**St Anthony of Padua Catholic School Redevelopment-Mod-1 (SSD-8865-Mod-1)
Submissions Report**

Attachment 1

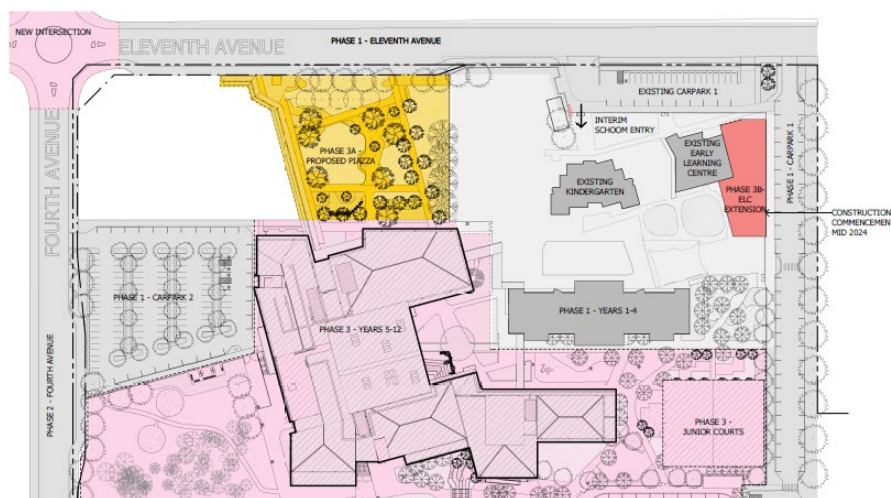
The phasing (aerial and 3D view) plans do not reflect the timing of the interim road design and the final roundabout design.

The revised traffic report prepared by Colston Budd Rogers & Kafes dated 27 August, identifies (at point 7-8 and 16) that the interim intersection design with the two approach lanes and give-way / stop signage at both Eleventh Avenue / Fourth Avenue and Tenth Avenue / Fourth Avenue is required to be constructed and operational prior to student enrolment reaching 1088. Additionally, the traffic report identifies (at point 16) that the roundabout design will be constructed and operational prior to student enrolment reaching 1350.

The Department considers that, to ensure the works are completed and operational at relevant phasing checkpoints, the proposal should be designed so that:

- i. The interim intersection design is constructed and operational before Phase 1 operation commences, when the student enrolment is at 975. This is the Department’s preferred option.

Alternatively, a new interim Phase between Phase 1 and Phase 2 could be introduced so that the interim intersection design is constructed and operational at this new interim phase and before the student enrolment reaches 1088.

- ii. The final roundabout intersection design is constructed and operational at Phase 2, and before the student enrolment reaches 1300.

The above will need to be clearly outlined in revised phasing plans (aerial and 3D views) and in the Response to Submissions Report (RtS).
